Addendum Number One

Drawings and Specifications Dated August 17, 2007

Portland Harbor Hotel Annex

468-470 Fore Street

2 BRICK SIDEWALK PAVEMENT DETAIL
N.T.S.

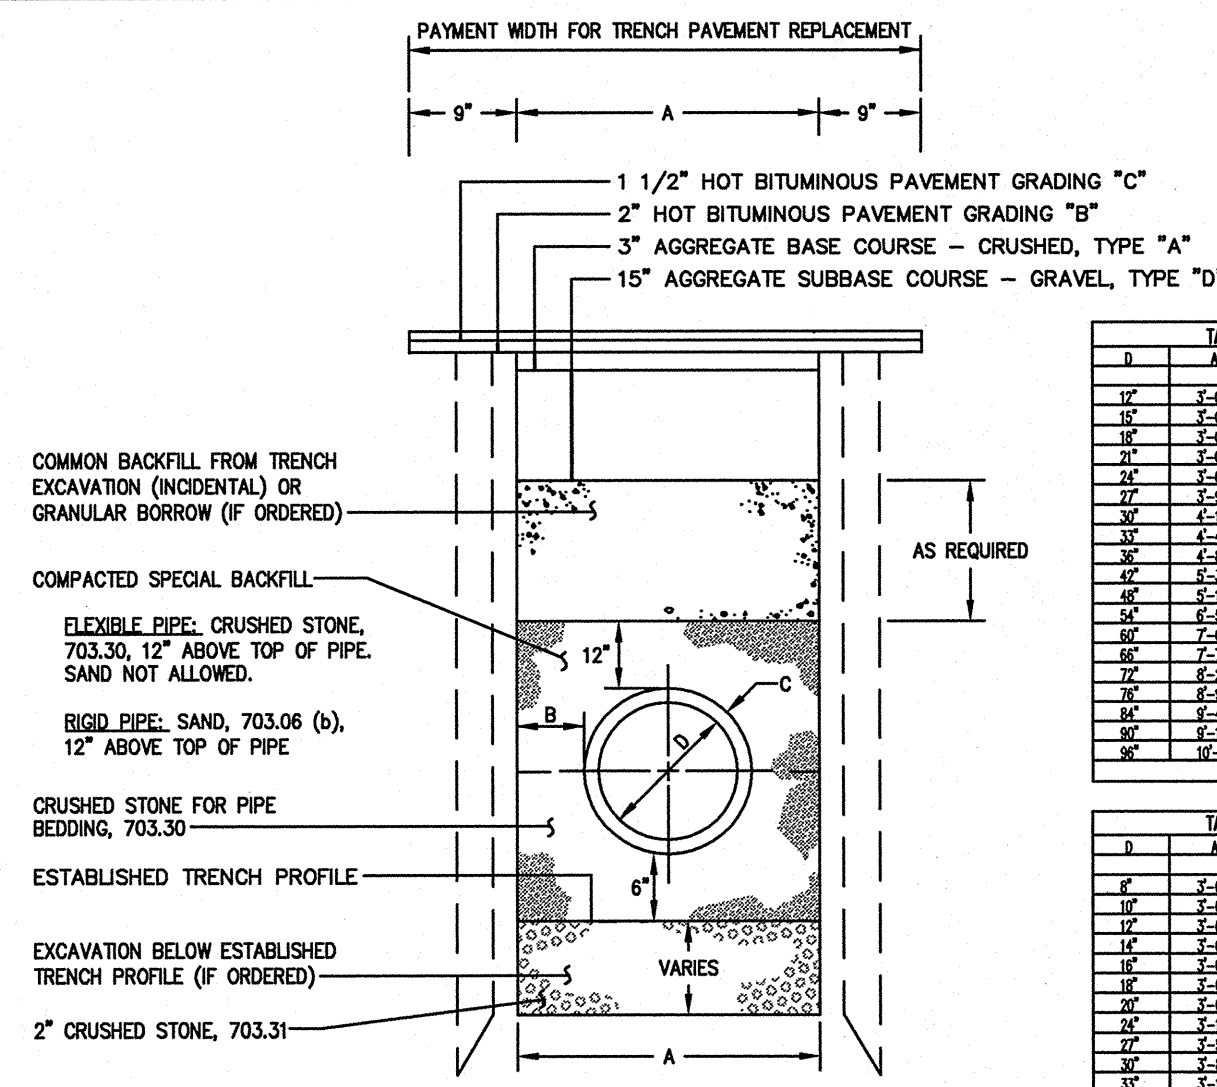
Q1. Will the bricks in the public sidewalk need to be reused or will new bricks be used?

A. Bricks in the public sidewalk will be re-used. Provide new bricks as necessary for replacement of unusable bricks and for filling in any locations where the existing bricks will not be sufficient.

**W3** 1 HOUR RATED EXTERIOR NON-LOADBEARING WALL

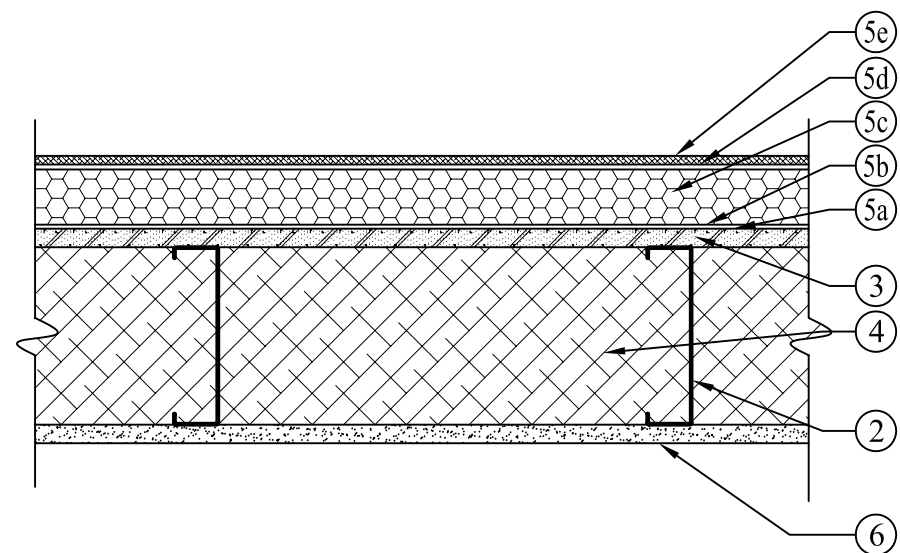
1. **Modification:** Sheet 4.01 – Wall Types; Changes to wall type W3. W3 Item 3 – Cementitious Backer Units: replace reference to “Durock Exterior Cement Board” with words “DensGlass Gold Exterior Sheathing”.

**W5** 1 HOUR RATED EXTERIOR NON-LOADBEARING WALL

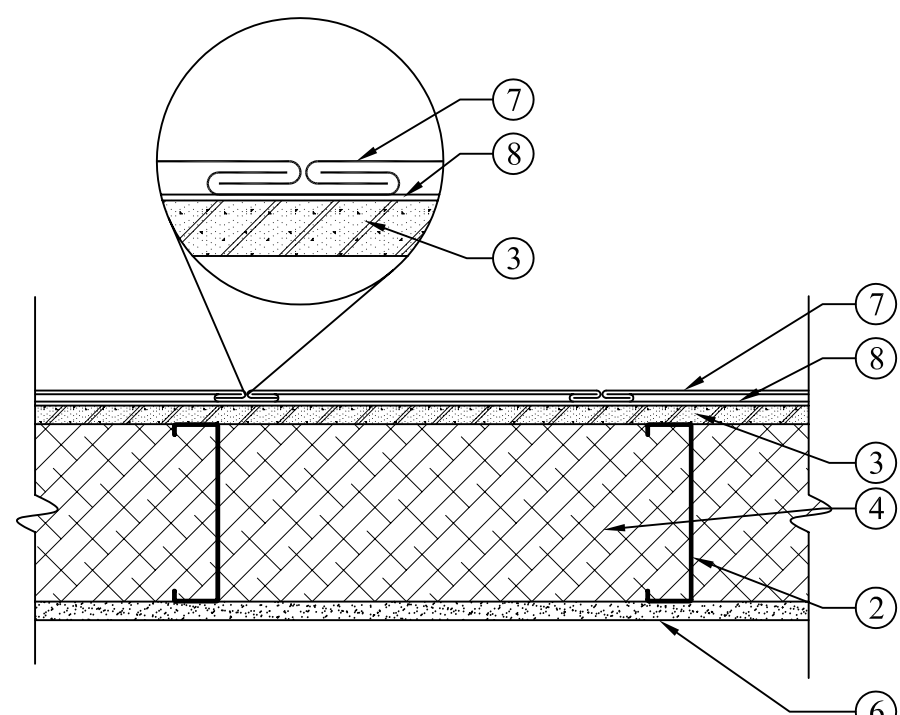
2. **Modification:** Sheet 4.01 – Wall Types; Changes to wall type W5. Title should read “W5 – 1 Hour Rated Exterior Lead-Coated Copper Siding Wall”. W5 Item 3 – Cementitious Backer Units: replace reference to “Durock Exterior Cement Board” with words “DensGlass Gold Exterior Sheathing”. W5 Item 8: delete words “15# felt”. Should read “Red Rosin Paper”. Red Rosin Paper is to be used behind ALL lead-coated copper siding.

**W9** 1-HOUR RATED BETWEEN EXISTING GARAGE AND NEW ADDITION

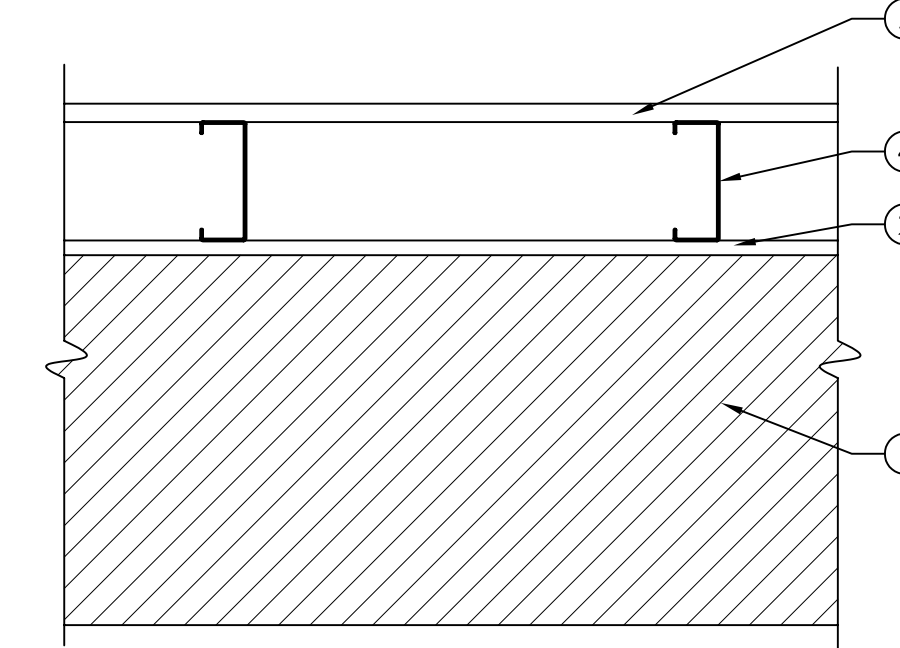
3. **Modification:** Sheet 4.01 – Wall Types; Changes to wall type W9. W9 Item 1 – Cementitious Backer Units: replace reference to “Durock Exterior Cement Board” with words “DensGlass Gold Exterior Sheathing”.

01 EXTERIOR WALL - GRANITE PANEL PLAN DETAIL
SCALE: 1 1/2"=1'-0"

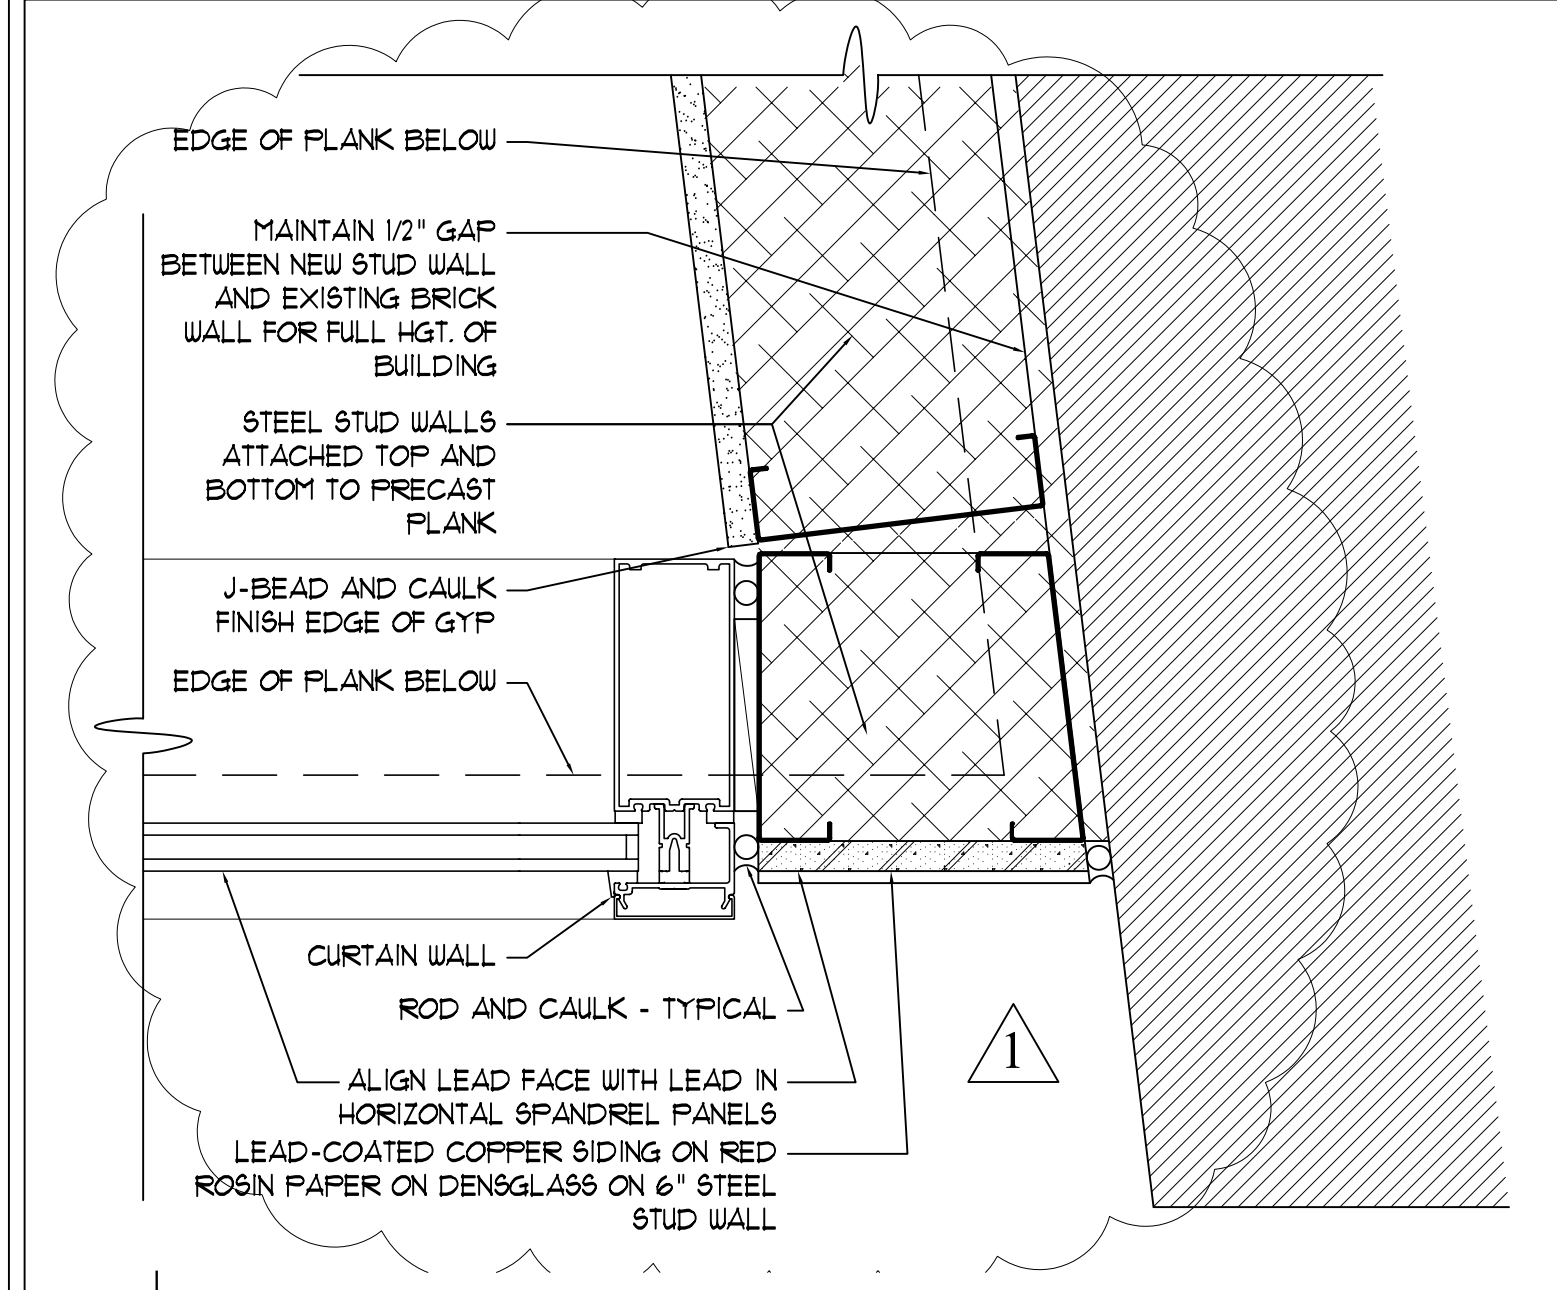
10. **Clarification:** Sheet A5.03 – Details; see attached drawing **AD1.9 – Plan Detail Granite Wall Entry Vestibule** for clarification of anchors for granite panels, shapes labeled ‘A’, ‘B’ and ‘C’.

11 PLAN DETAIL - CURTAIN WALL END DETAIL AT BRICK WALL
SCALE: 3"=1'-0"

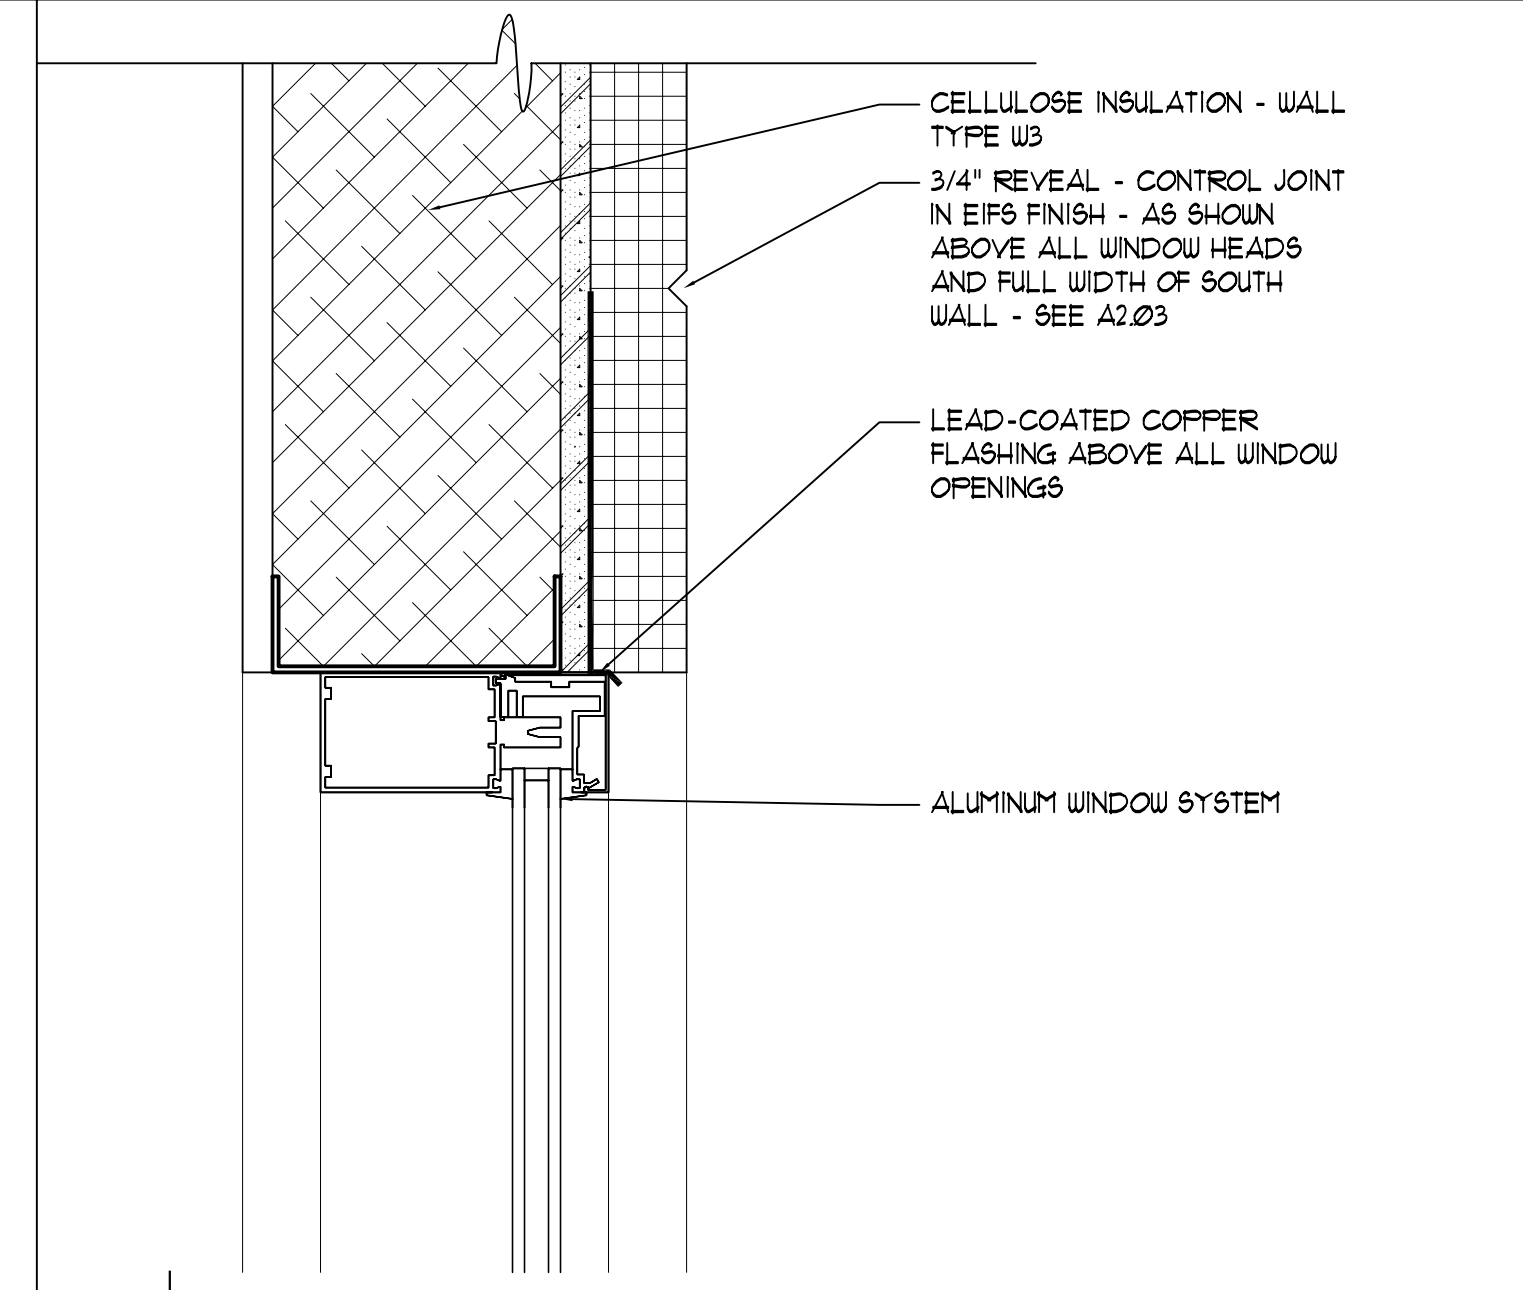
4. **Clarification:** Sheet A5.03 – Details; See accompanying drawing **AD1.1 – Plan Detail North Elevation** for additional detail 11/A5.03 for connection of new north façade curtain wall to existing brick wall.

12 SILL DETAIL - GRANITE PANELS AT VESTIBULE
SCALE: 1 1/2"=1'-0"

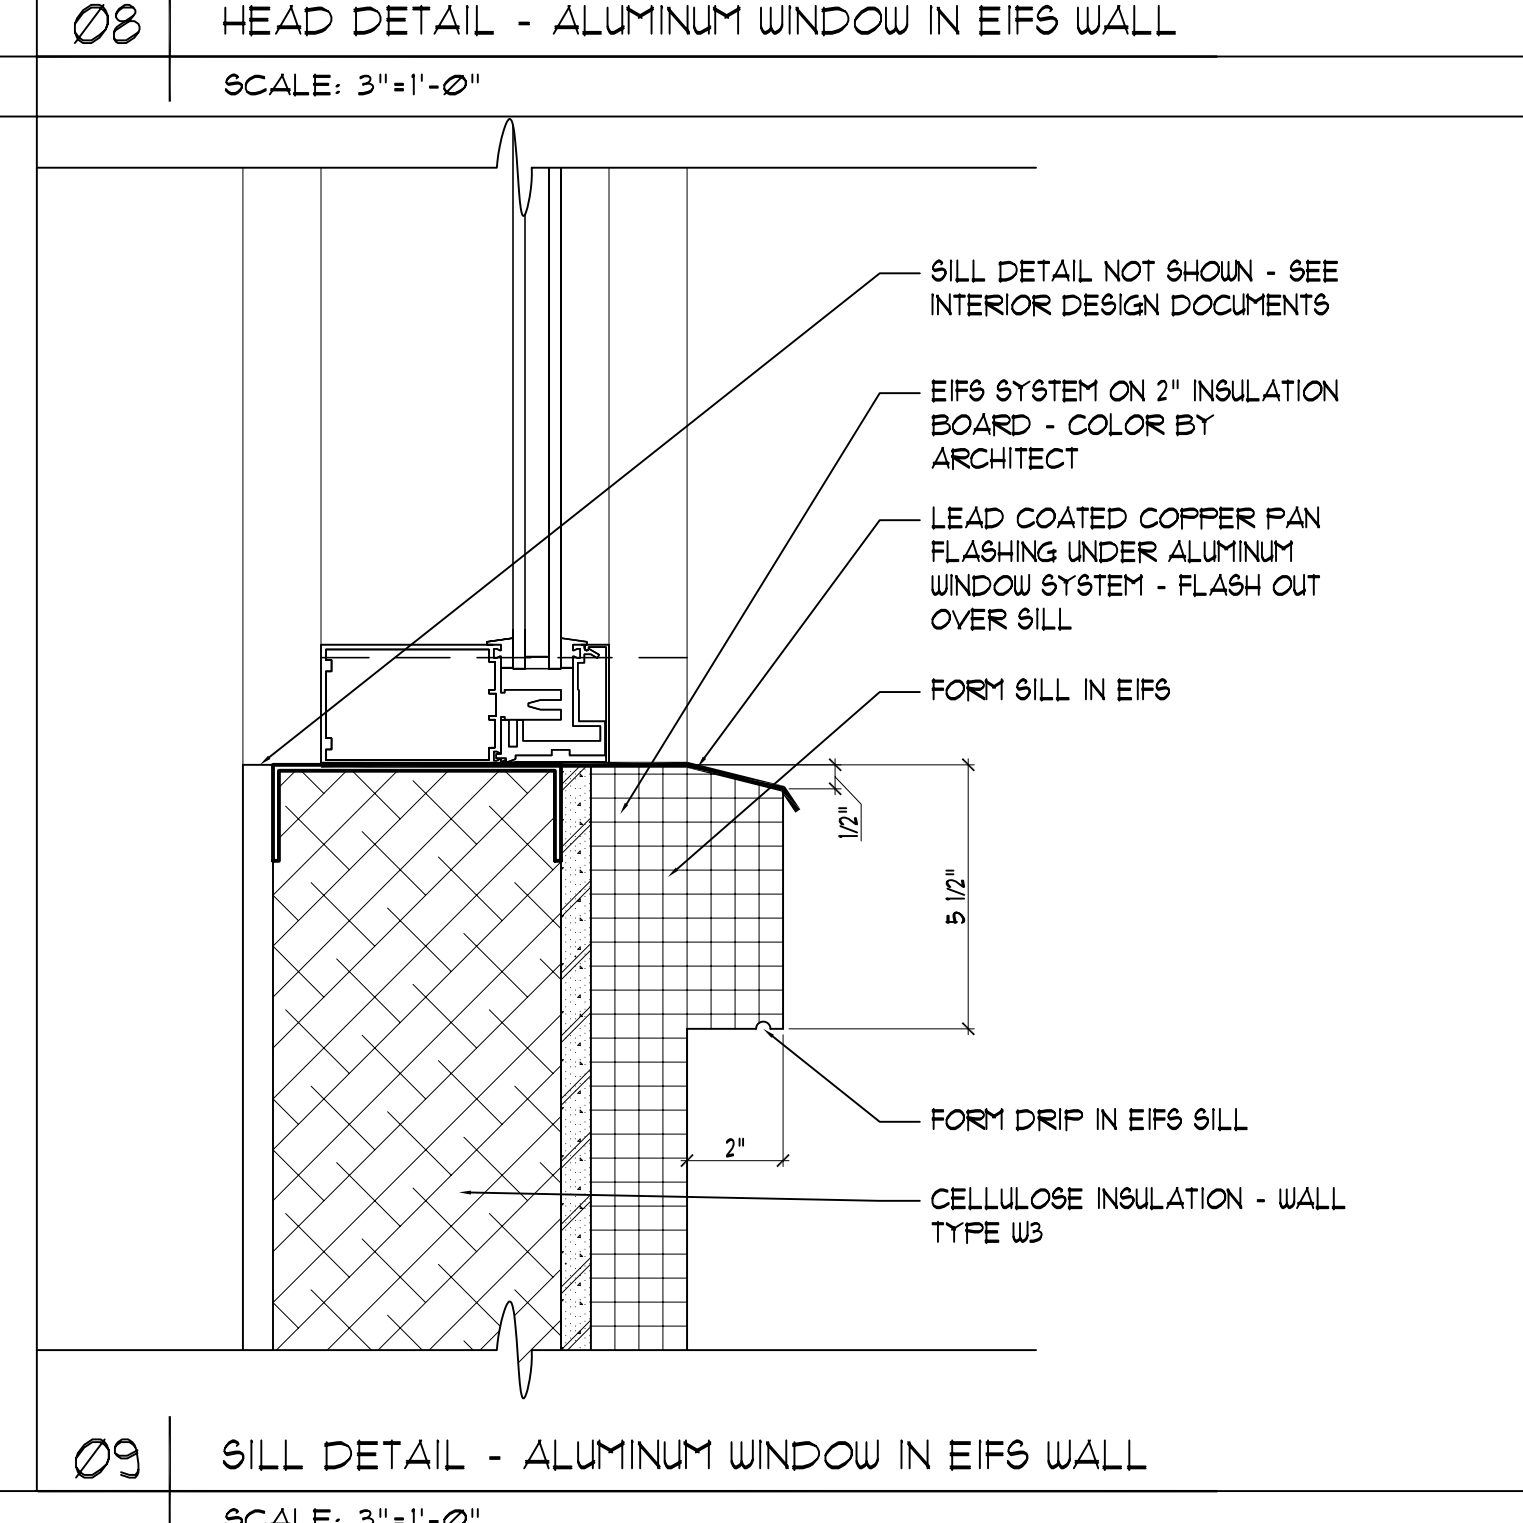
5. **Clarification:** Sheet A5.03 – Details; See accompanying drawing **AD1.2 – Sill Detail Granite Wall** for additional detail 12/A5.03 for granite panel sill detail.
